Appeal Decision

Appeal Ref: APP/R5510/D/24/3344541

4 Clevedon Gardens, Hayes, Hillingdon UB3 1RE

- The appeal is made under section 78 of the Town and Country Planning Act 1990 (as amended) against a refusal to grant planning permission.
- The appeal is made by Mr Ardavan Lafzi against the decision of the Council of the London Borough of Hillingdon.
- The application Ref is 78353/APP/2023/3013.
- The development proposed is 6m single storey rear extension, with flat roof.

PROPOSED
SIDE ELEVATION-01

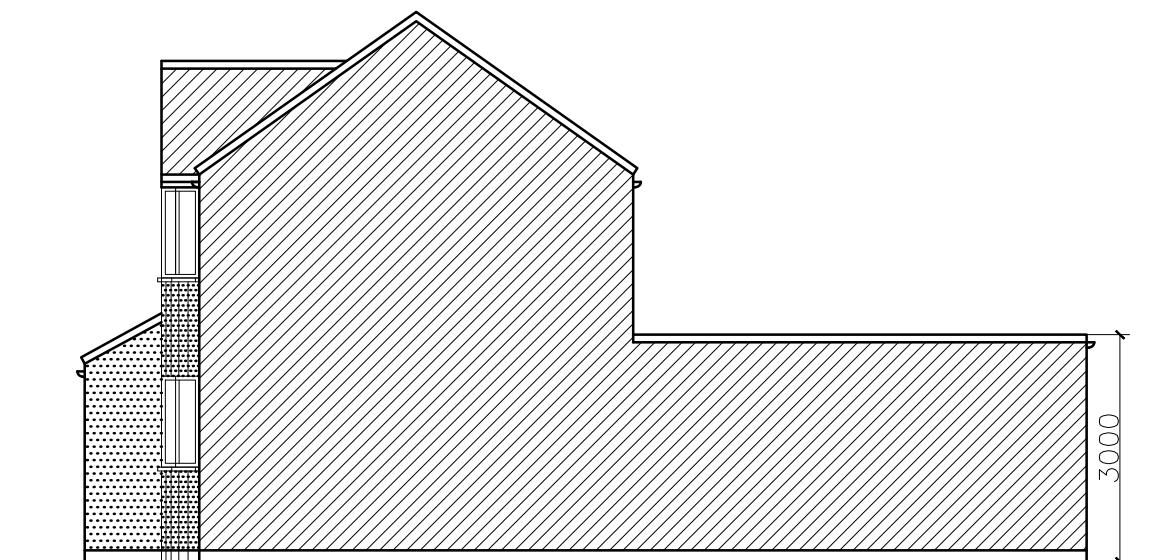
3. The proposed extension would extend across the full width of the rear elevation of the host property at a depth of 6m, with a 3m high flat roof. Notwithstanding that the extension would not be visible from the street scene, the Council's figures indicate that the ground floor area of the appeal property would be almost doubled, thereby demonstrating that the extension would not be subordinate. In my judgement its volume would dwarf the host dwelling and it would appear disproportionate and incongruous.

4. Furthermore, the proposed extension would extend well beyond the depth of the two neighbouring extensions. It would also exceed the maximum depth for extensions as set out in Policy DMHD 1. The depth and resulting mass of the extension would harm the character and appearance of the surrounding area.

6. I conclude that due to its depth, the scale and massing of the proposed extension would be unsympathetic to the design of the host dwelling and would harm its character and appearance as well as the visual amenities of the area. For these reasons the proposal conflicts with Policy BE1 of the Hillingdon Local
